TURF MASTER VARIANCE OF USE

7695 PONCA ROAD,
LOT 6, BLOCK 1, PAWNEE RANCHEROS FILING NO. 1,
IN EL PASO COUNTY, COLORADO

V2 - Site Plan Drawing - RLR.pdf Markup Summary

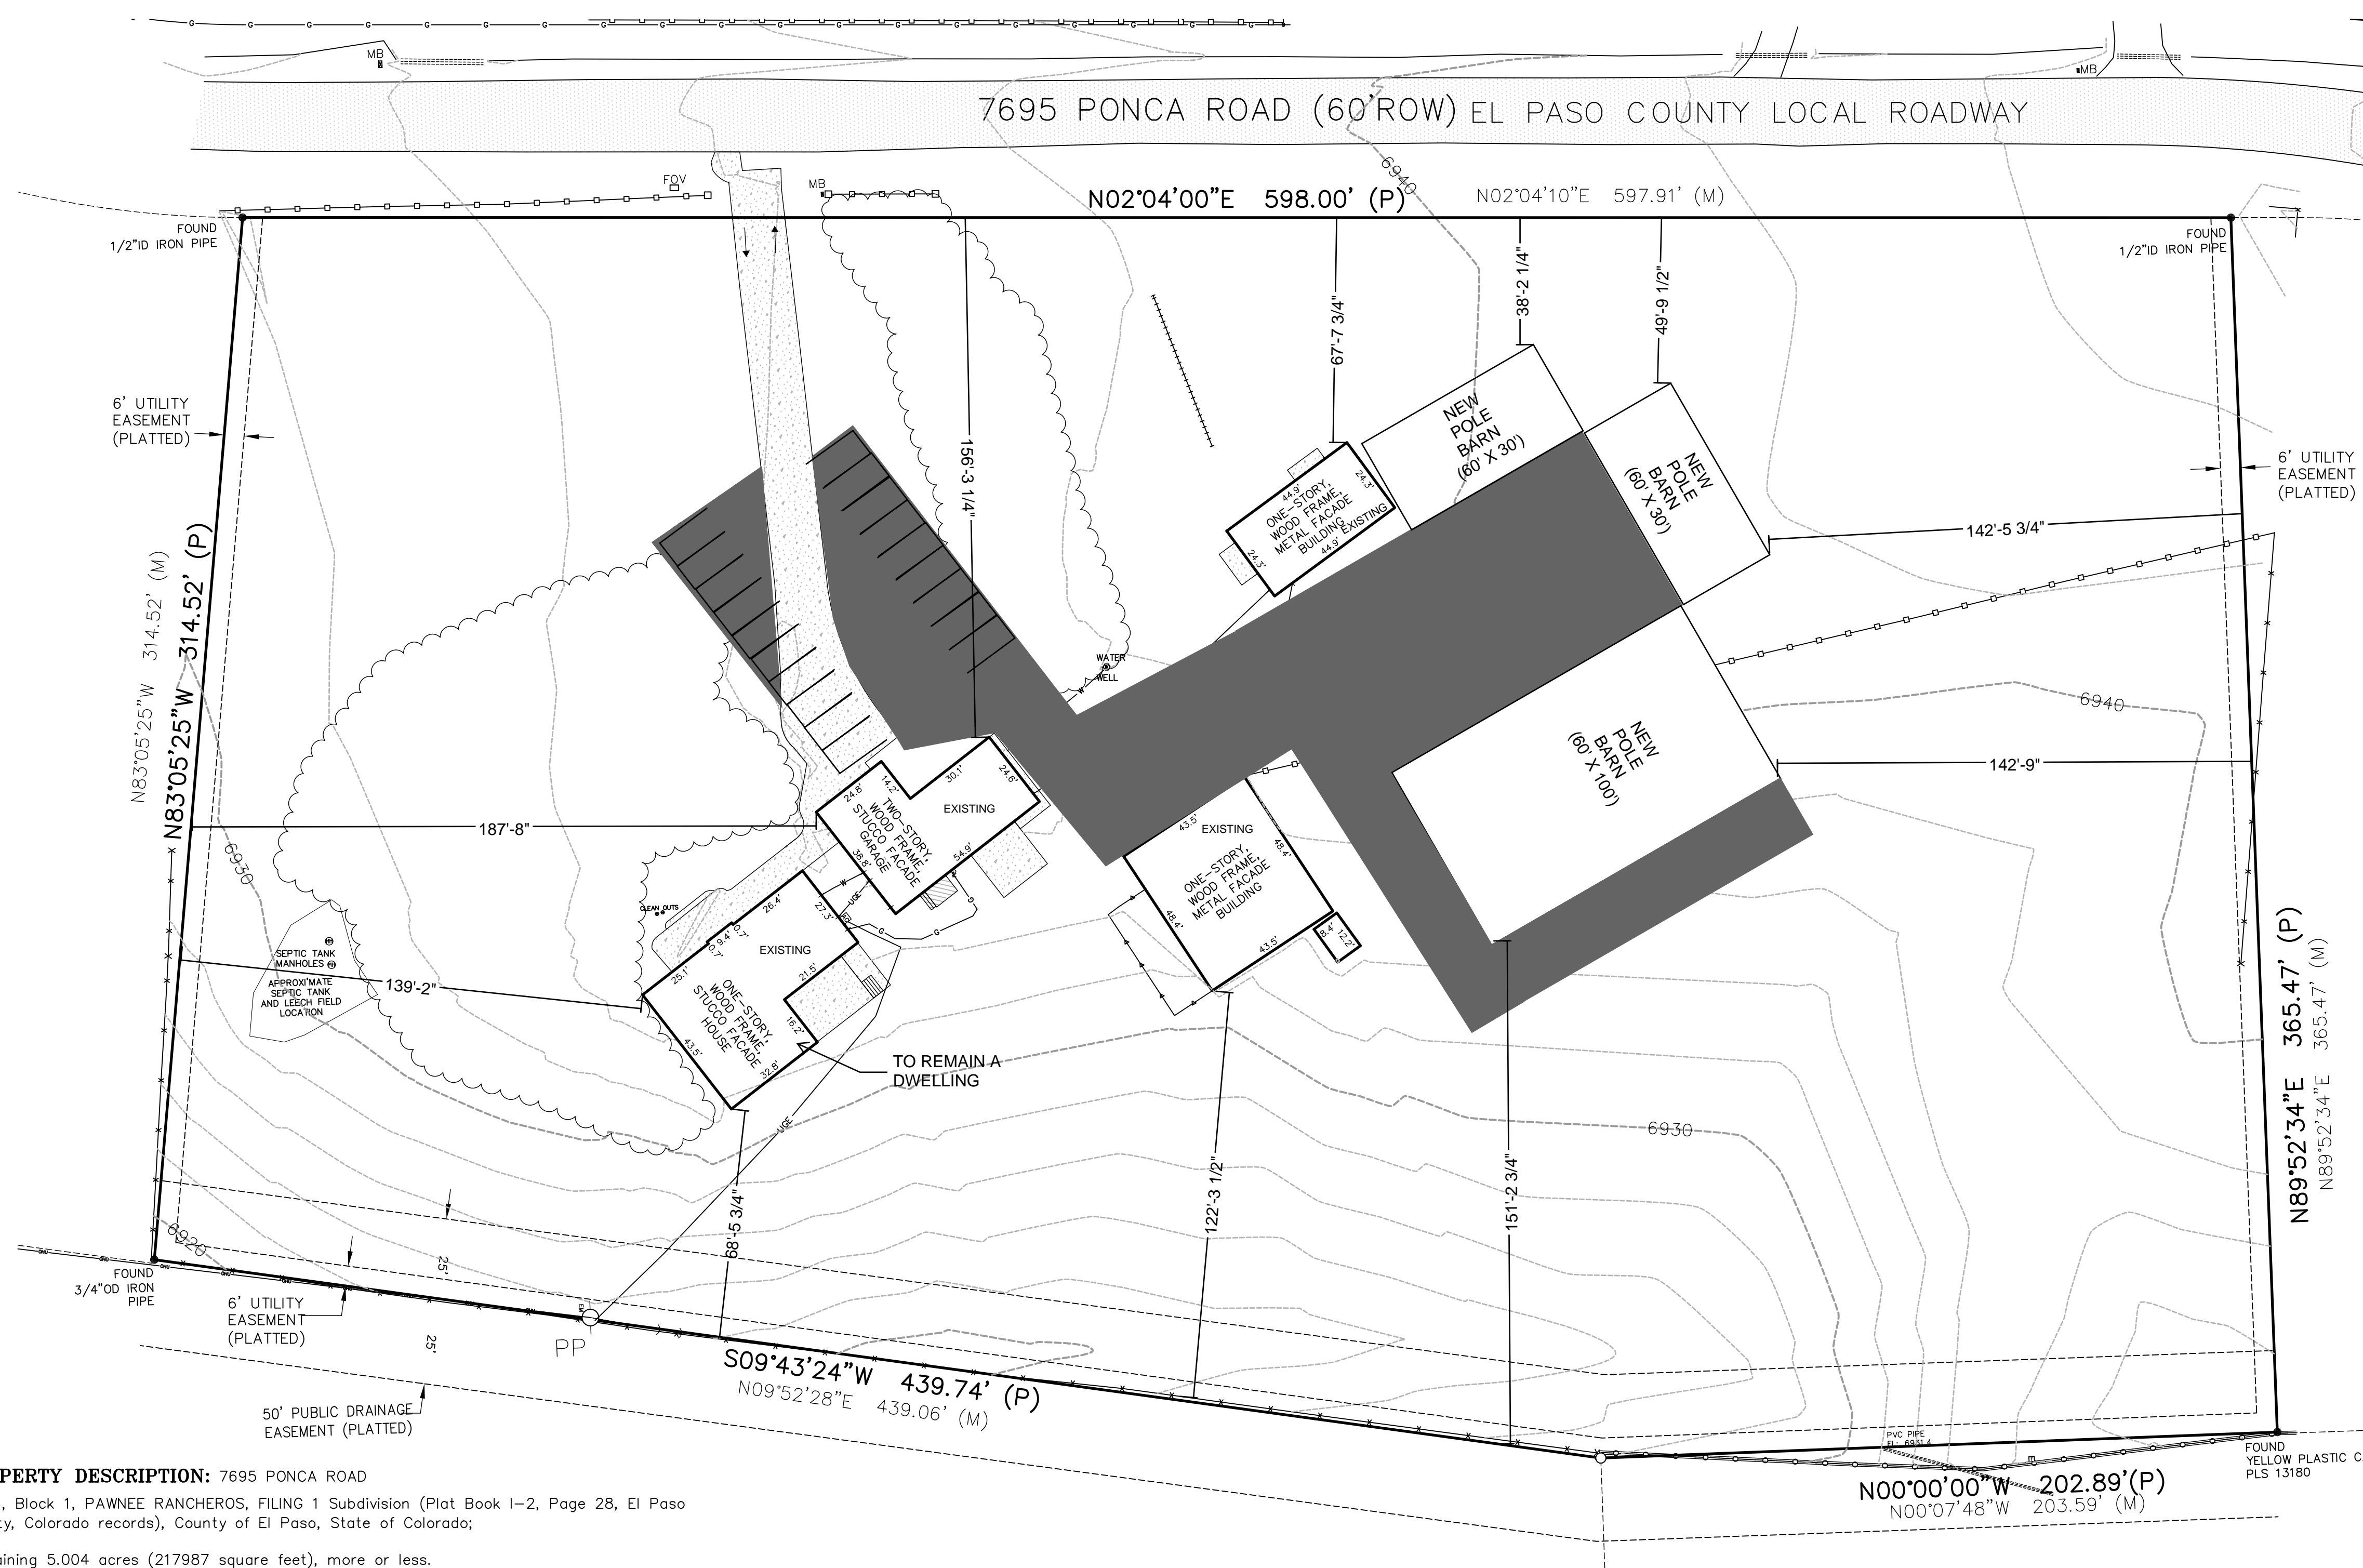
Review 1 comment:
Inconsistent with the LOI
Review 2 comment:
Unresolved. Still inconsistent with the LOI.

Review 1 unresolved comment. Please add:
PCD File No: VA248
